CLAREMONT BUSINESS PARK 2 FILING NO. 2

CONSTRUCTION PLANS

JUNE 2023

EL PASO COUNTY FILE NO. VR233

18" RCP RIPRAP APRON SECTION C-C  
SCALE: NTS

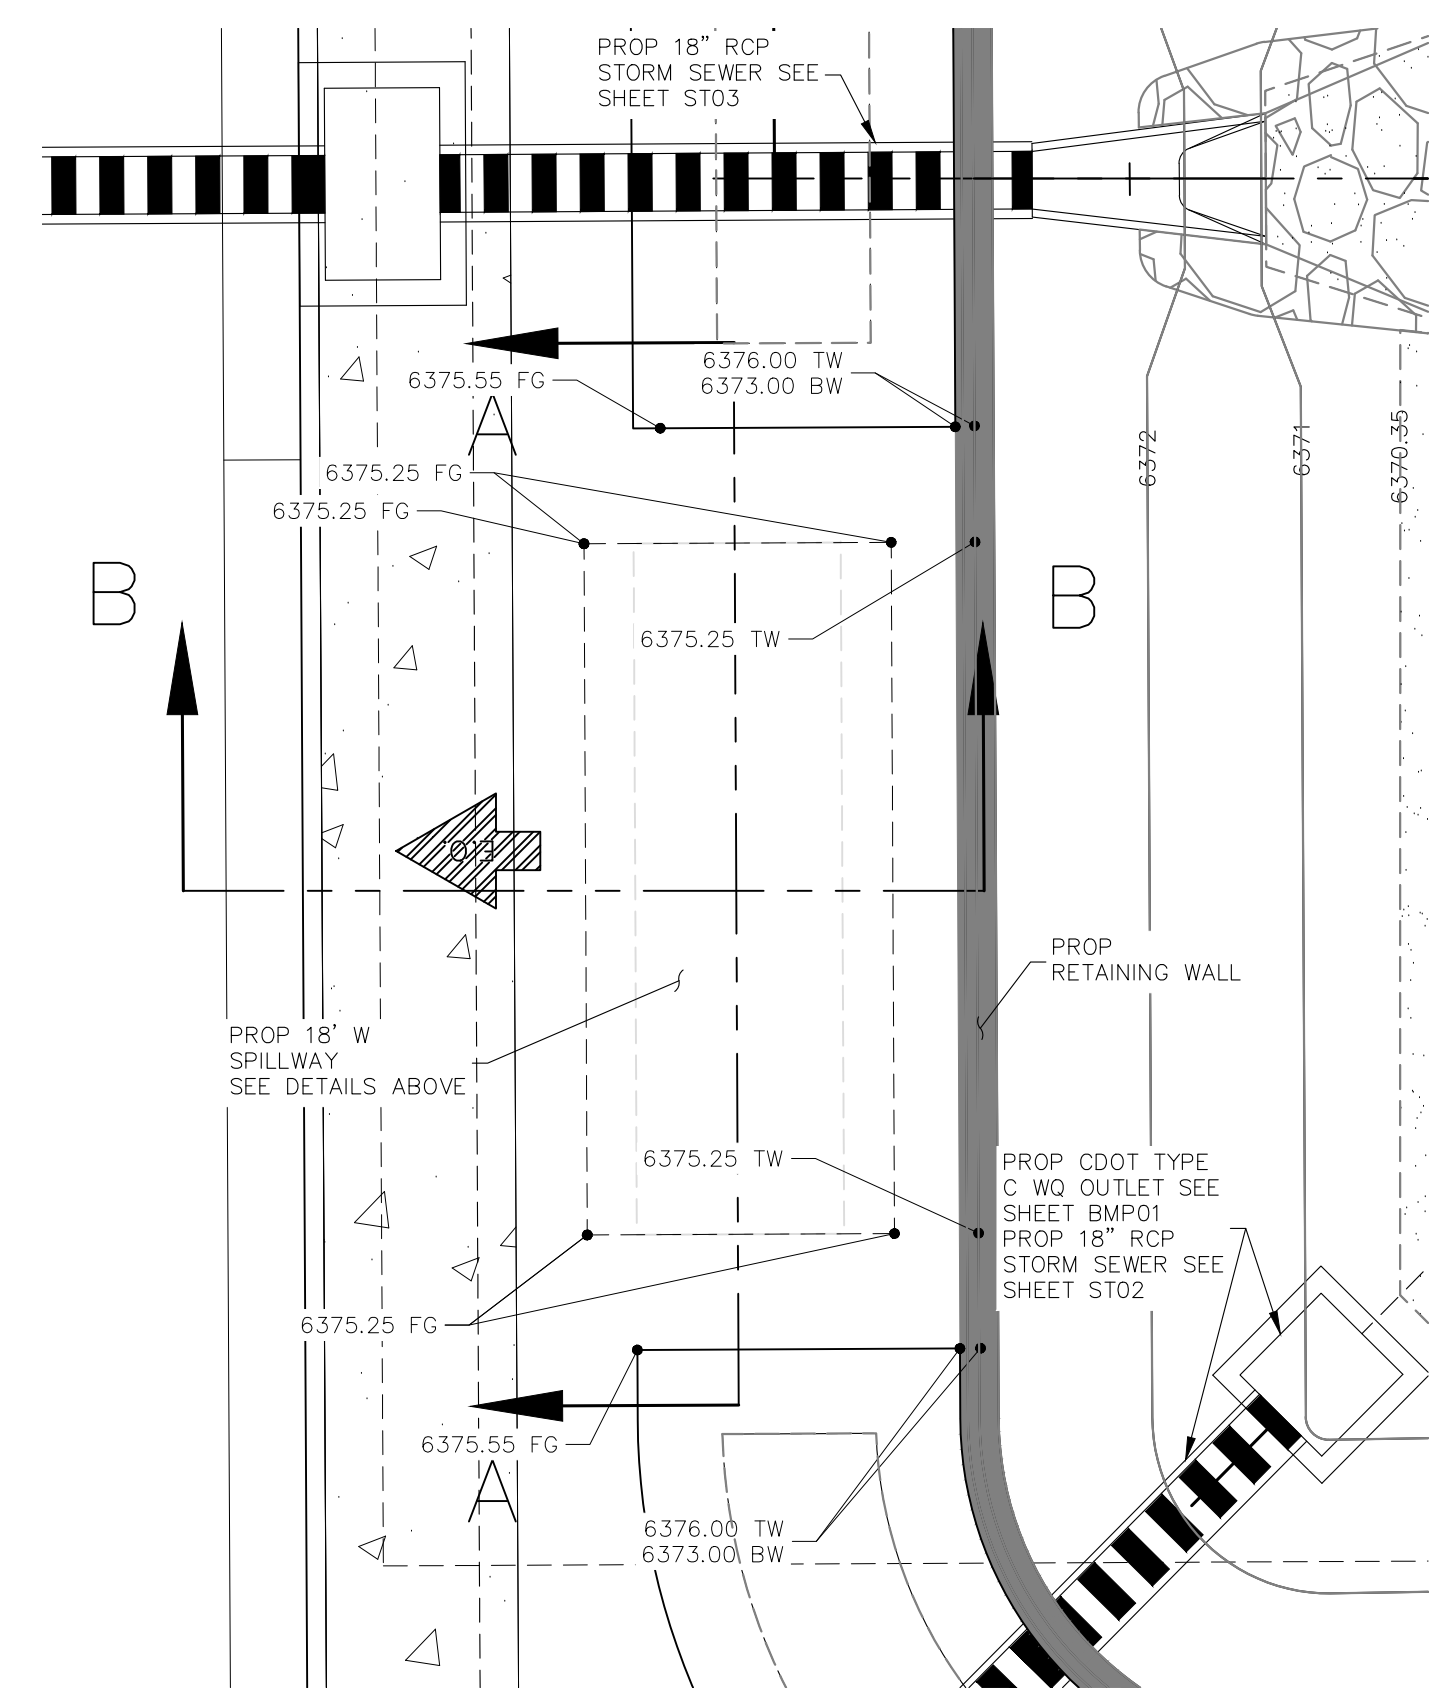
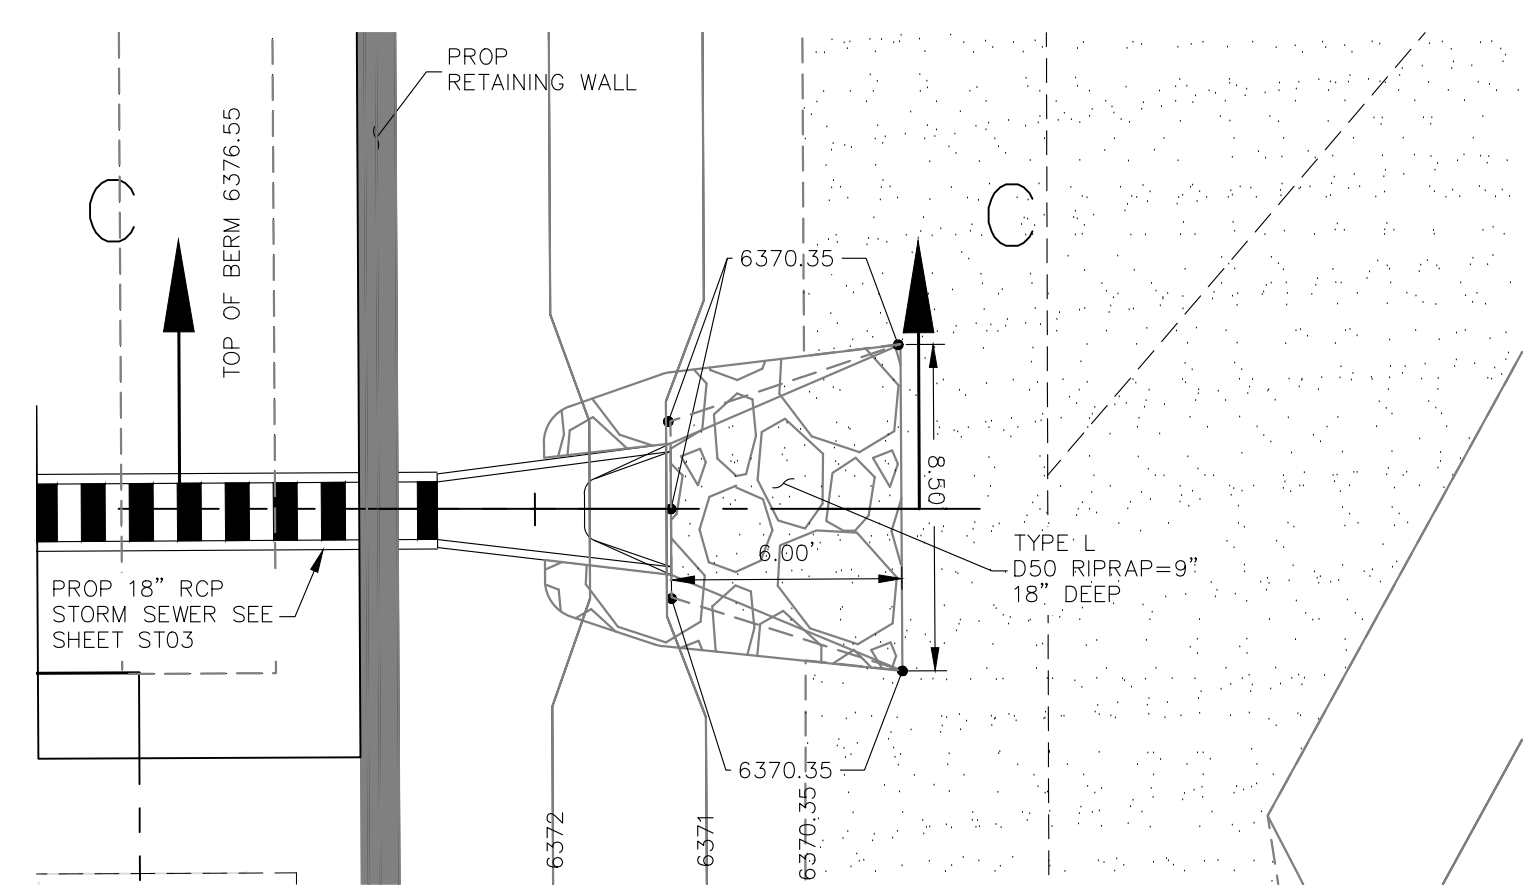
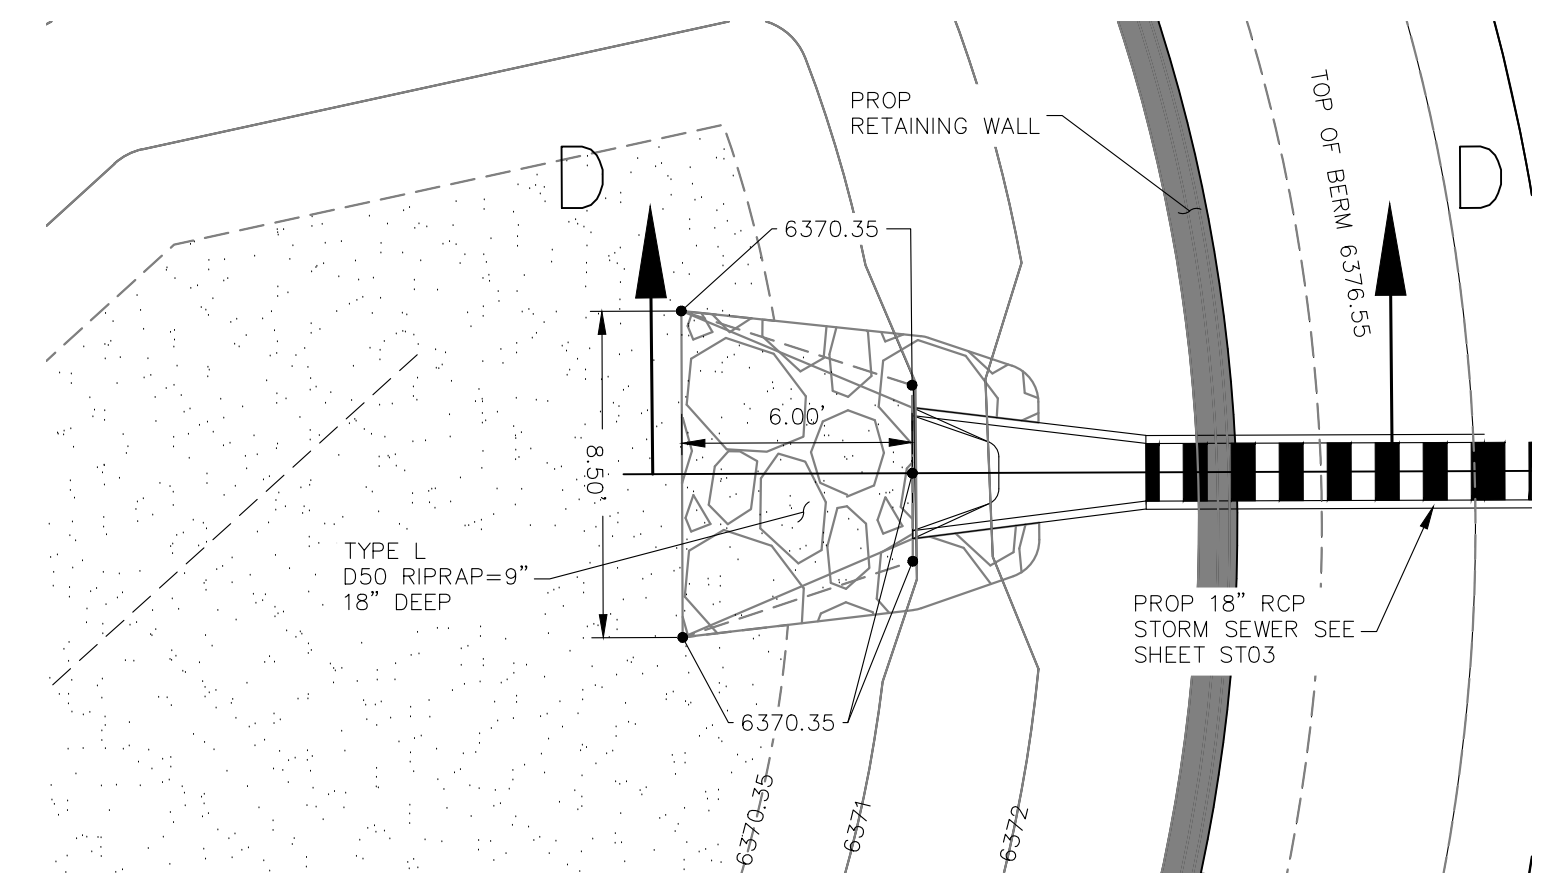
Unresolved: Provide riprap details
 Details are included within the BMPs. Please refer to sheet BMP02 on page 13 of this sheet set and view the riprap details titled "18" RCP RIPRAP APRON" Sections C-C and D-D.
